Town & Country Planning Act 1990 (as amended)
Town and Country Planning (Development Management Procedure) (England) Order 2015
Application for approval of details reserved by condition imposed under AL/51/17/PL relating to
conditions 3-surface water drainage, 5-site set up during construction, 6-schedule of materials &
finishes, 7-details of new screen fence, 8-dustbin enclosure details & 10-covered & secure cycle
parking.
Woodgate Farm Westergate Street, Westergate,

Condition Number 7

FENCE LOCATIONS
2016/36 / SK-2

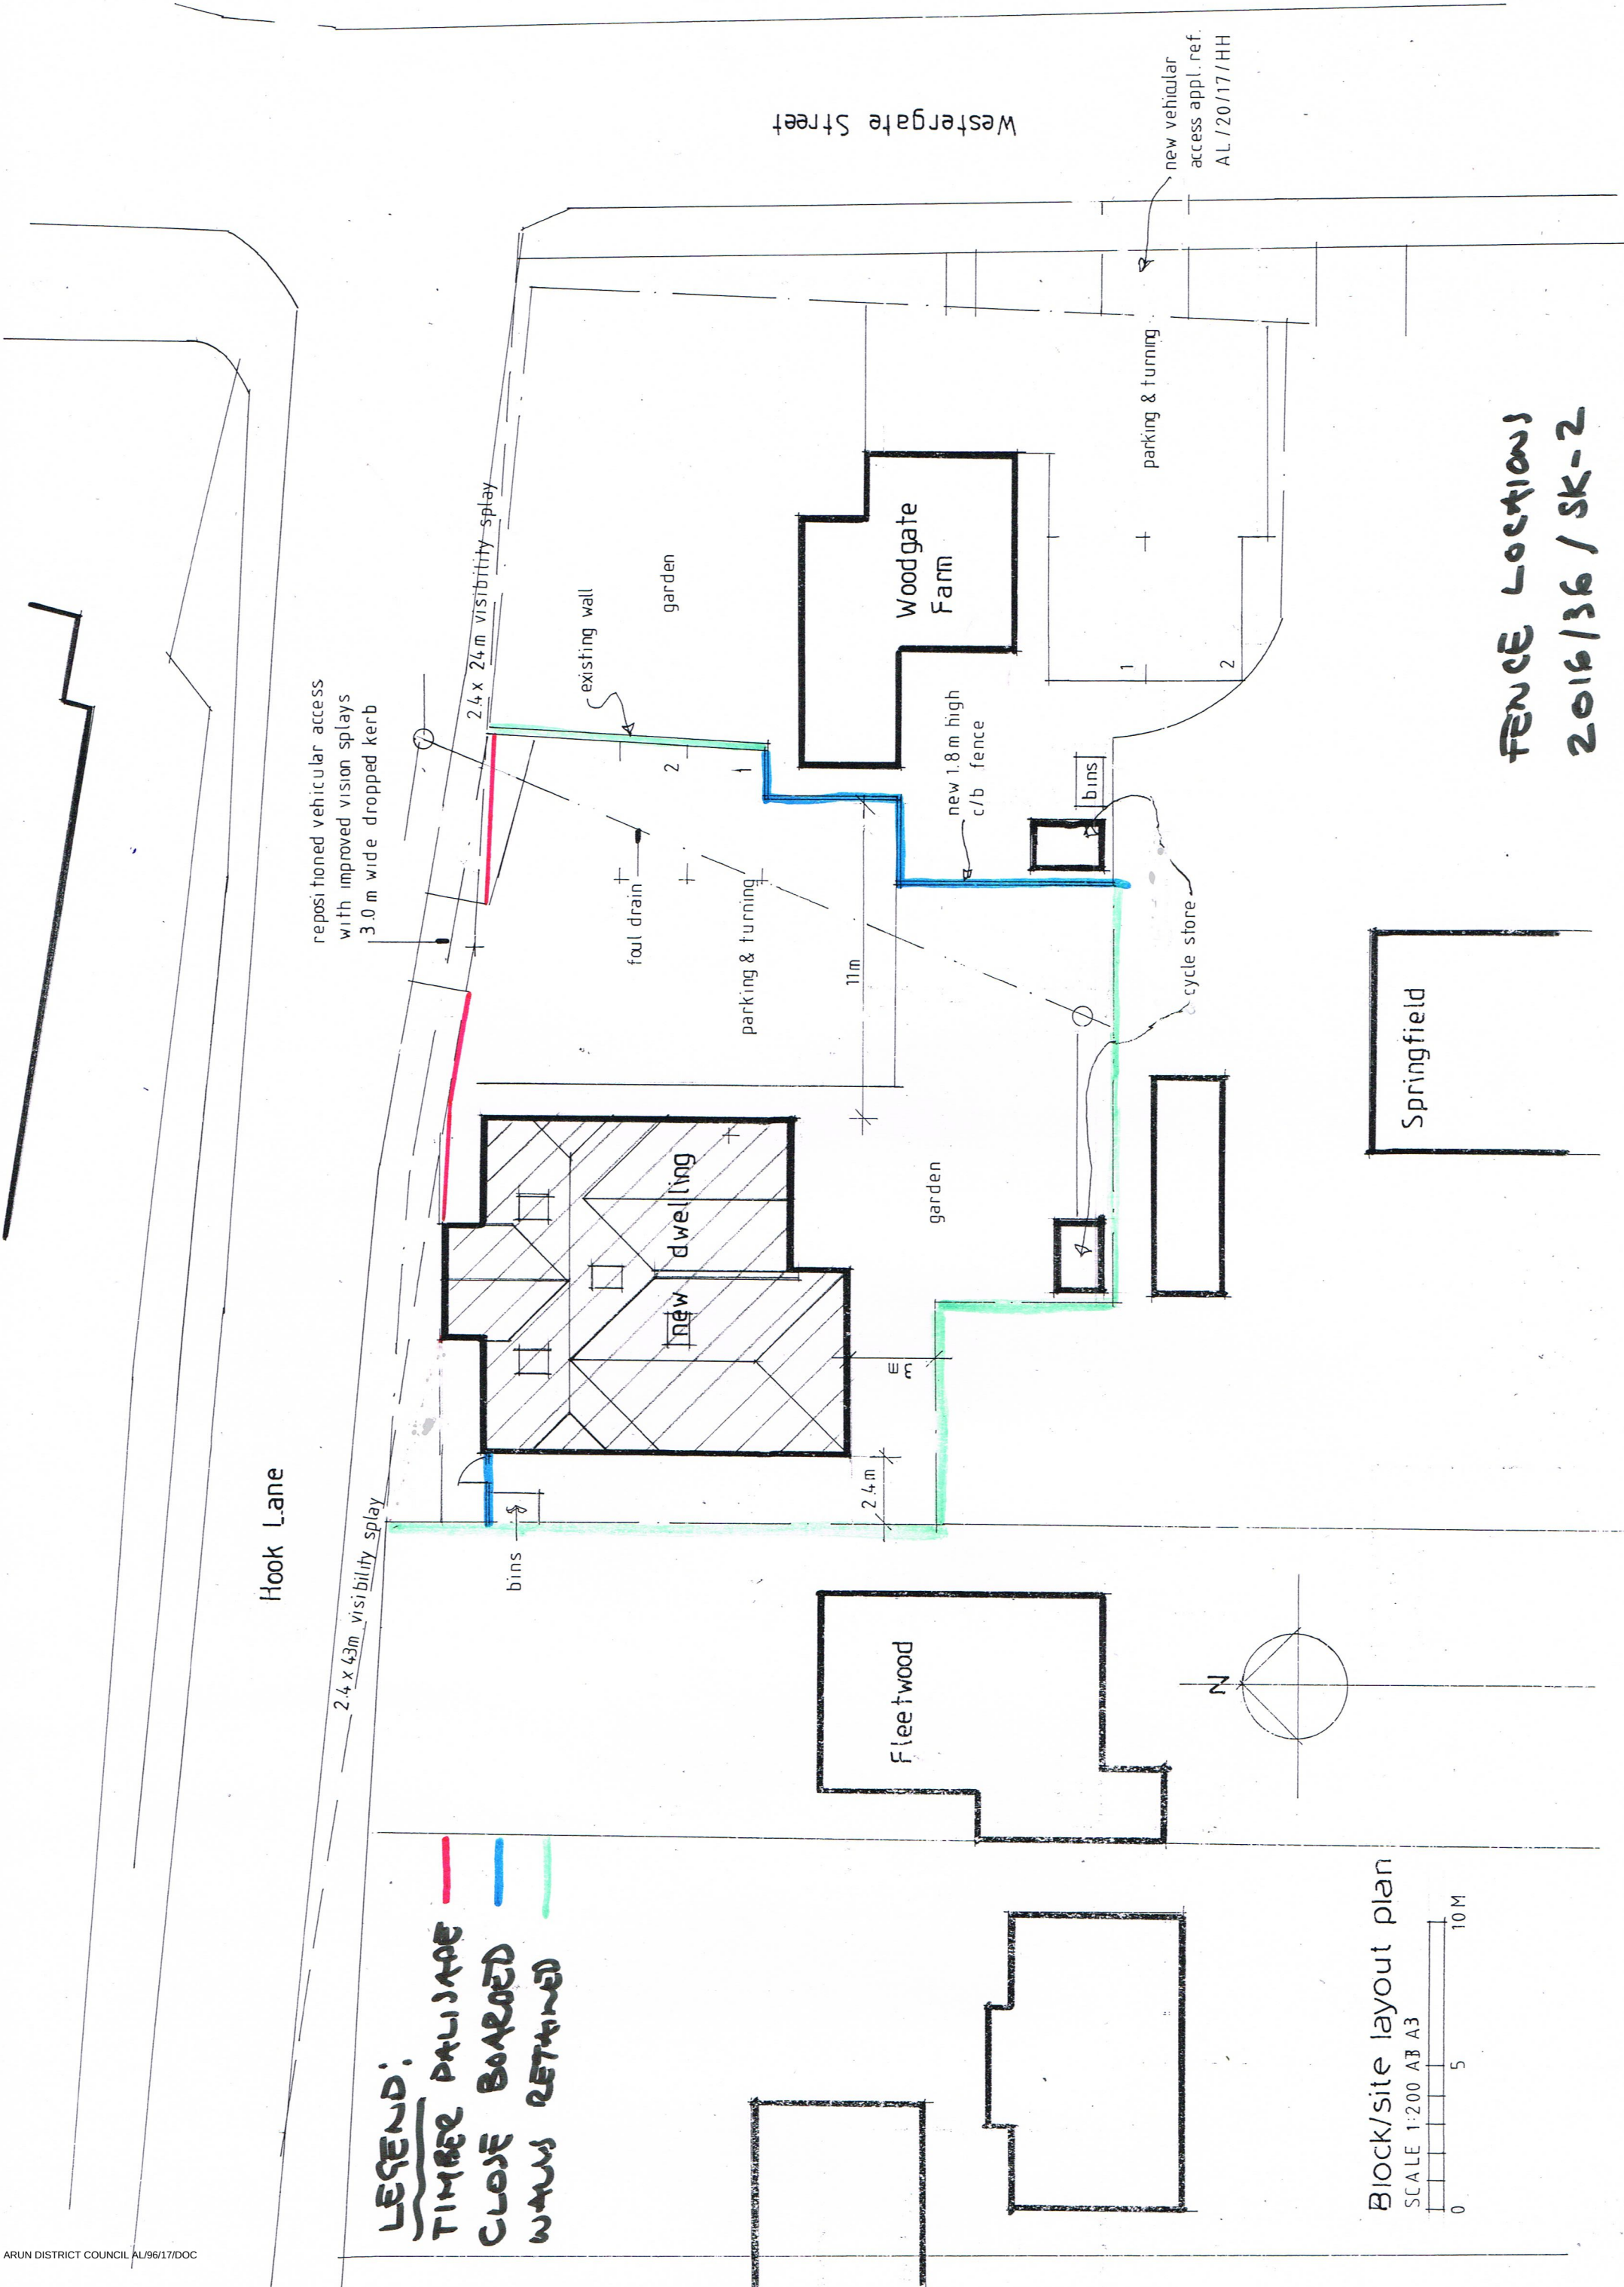
The submitted details in respect of the new boundary treatments namely the proposed use of 1m high timber palisade along the site frontage and 1.8m high close boarded fencing on part of the boundary to Woodgate Farm (with walls retained to the other boundaries) as shown on Drawing 2016/36/SK-2 "Fence Locations" and detailed by the elevation drawings SK-3 and SK-4 are considered to provide an acceptable scheme and satisfies the requirements of the condition.
